**From:** Laura Gibbons [REDACTED]  
**Sent:** 20 April 2021 09:16  
**To:** Anita Gardner <Anita.Gardner@arun.gov.uk>  
**Cc:** Planning.Responses <Planning.Responses@arun.gov.uk>  
**Subject:** Re: FW: Planning Consultation on: CM/11/21/DOC

**Application No:** CM/11/21/DOC  
**Registered:** 5th March 2021  
**Site Address:** Scyld Horsemere Green Lane Climping BN17 5QZ  
**Description of Works:** Approval of details reserved by condition imposed under CM/21/19/PL relating to conditions 11-surface water drainage scheme, 12-discharge of flows to water courses or for the culverting, diversion, infilling or obstruction of any water course on or adjacent to site & 13-maintenance and management of surface water drainage system.

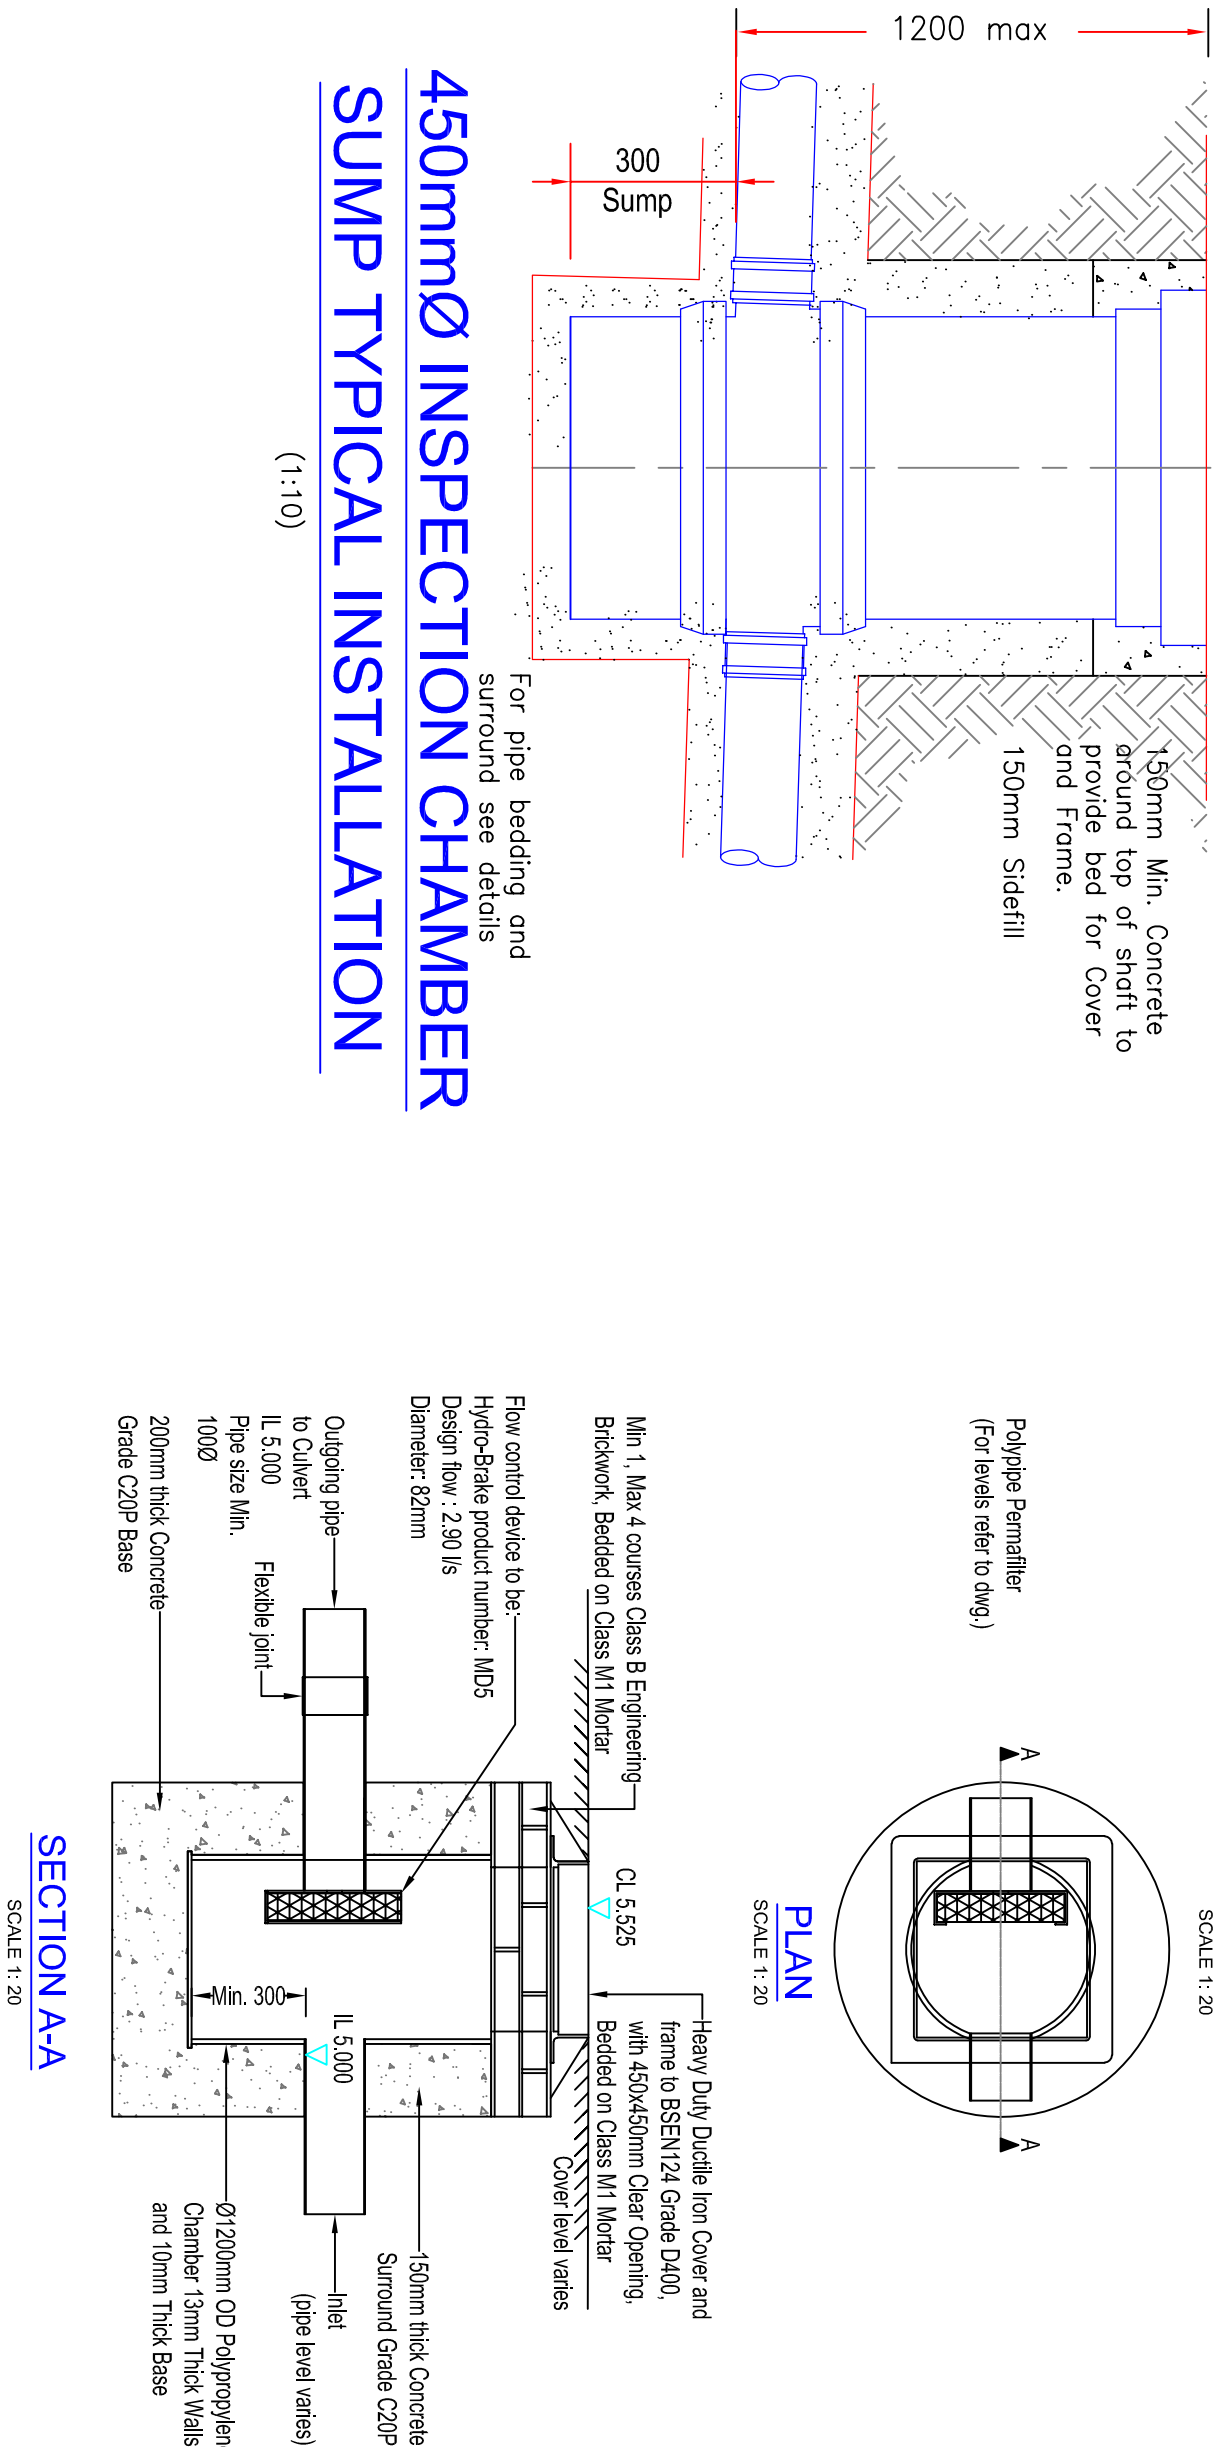
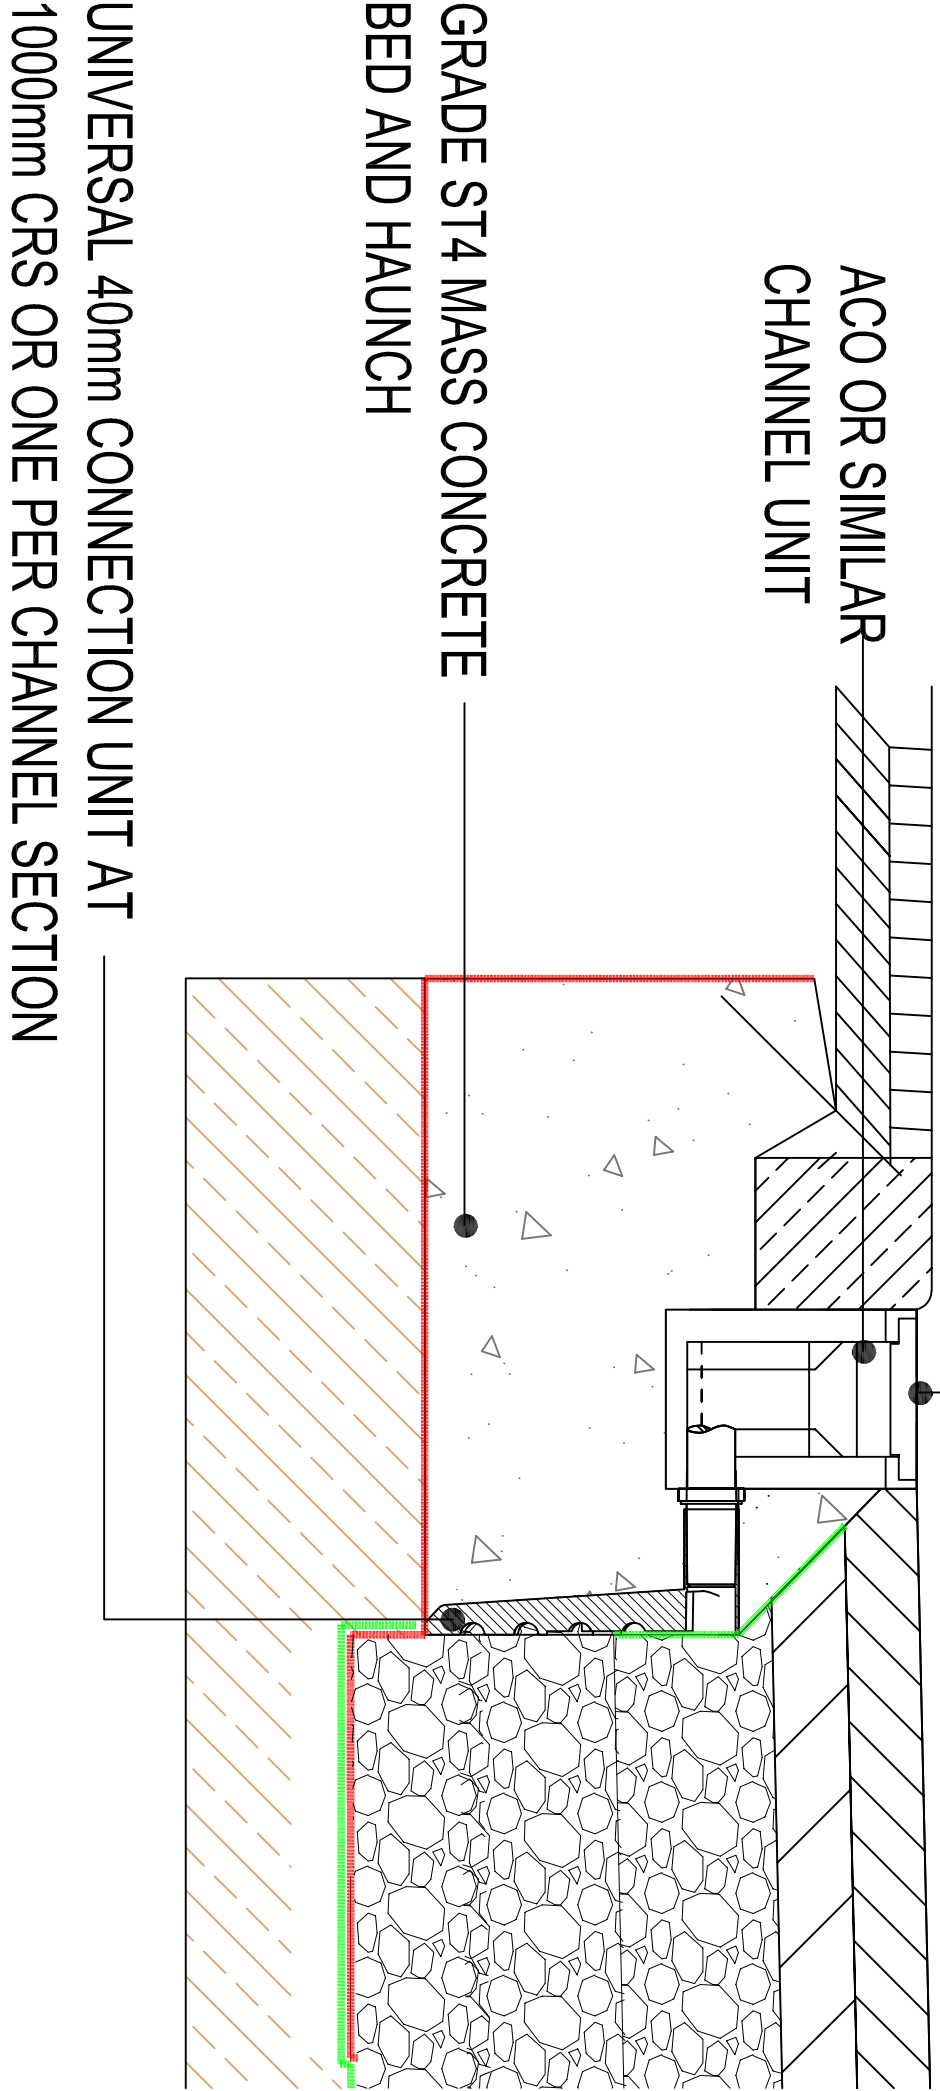
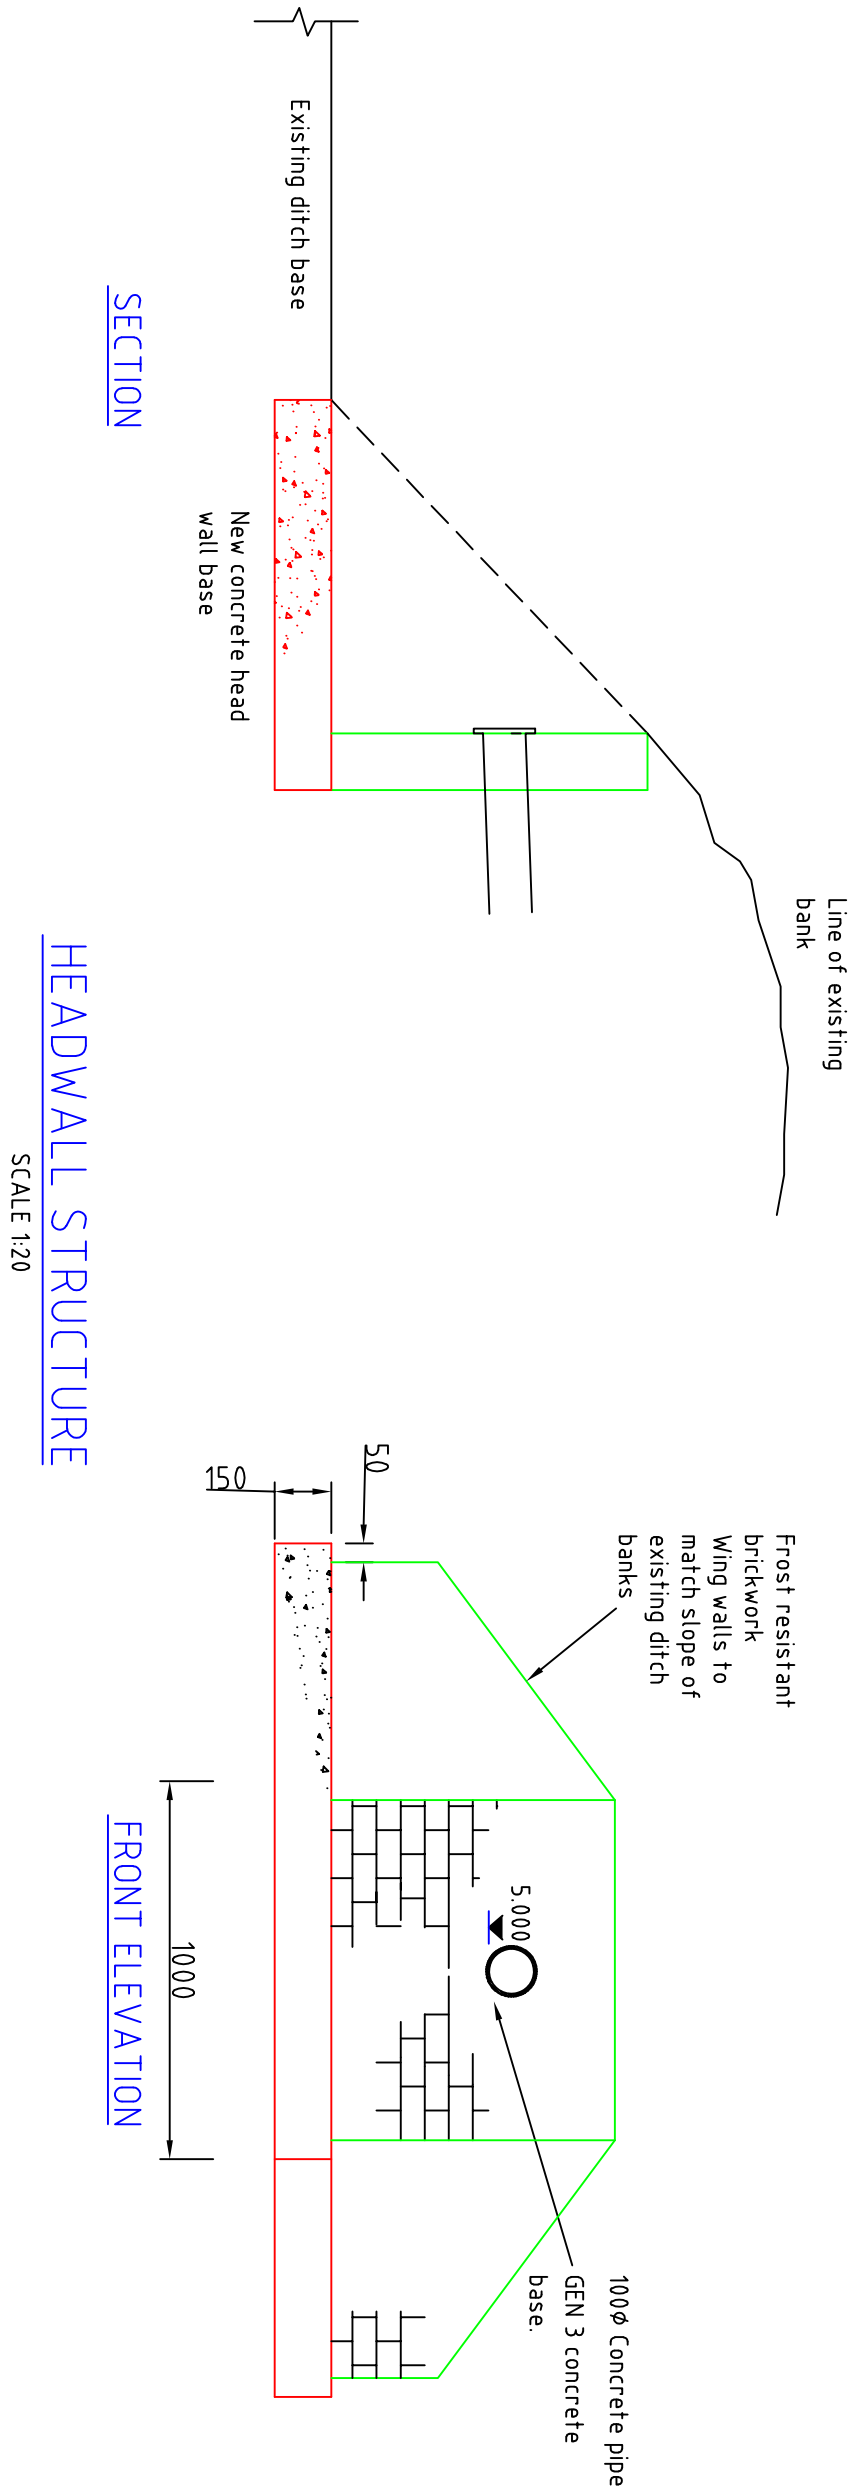
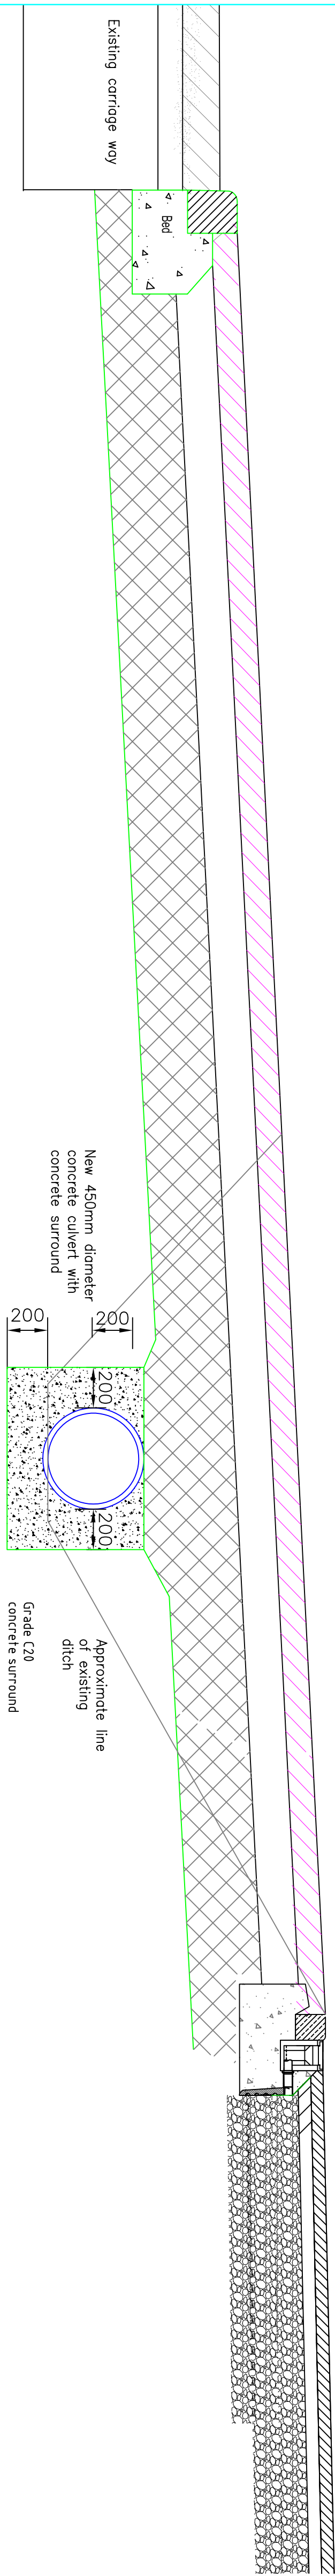
3. The long section on the drainage details sheet 1 refers to a hydrobrake with a restriction of 2.0l/s, which conflicts with the calculations, other details and layout (although addressing point 1 will affect these). This is now correct after the revised calculations, other details have been updated accordingly. See comment below.

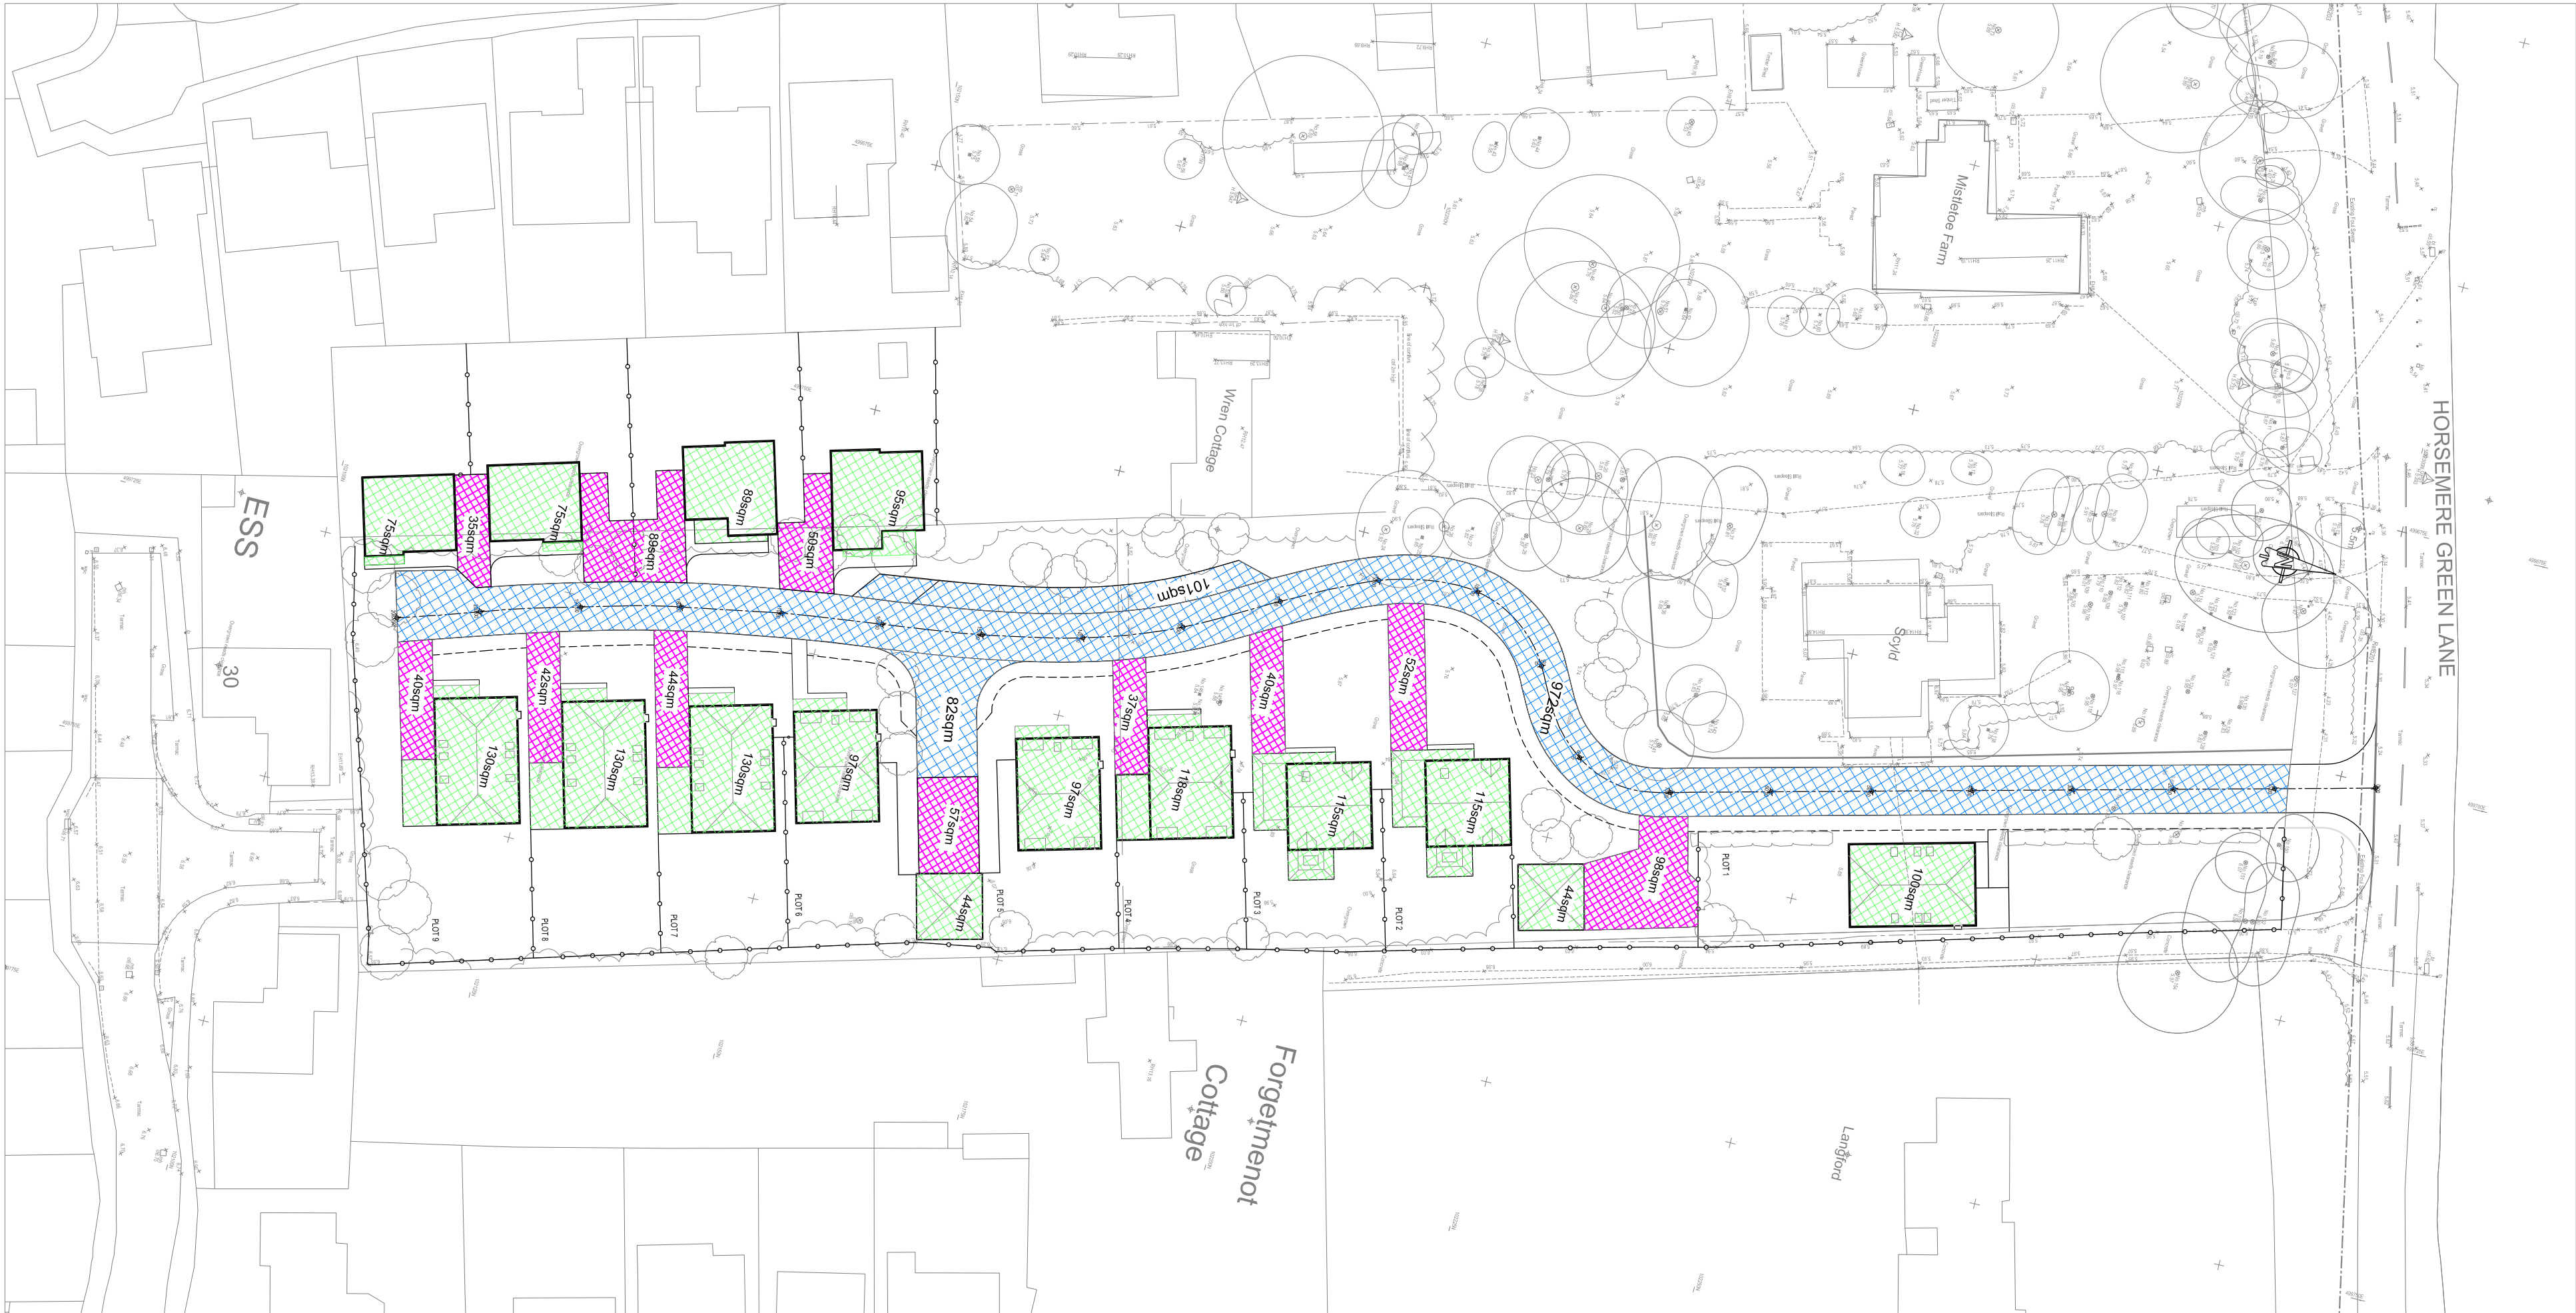
2. The impermeable areas plan appears to use an old layout, not the latest layout as approved under CM/55/20/PL. Please provide an updated impermeable areas plan. Updated plan attached to be read alongside the new calculations / drainage modelling. *Okay, point closed.*
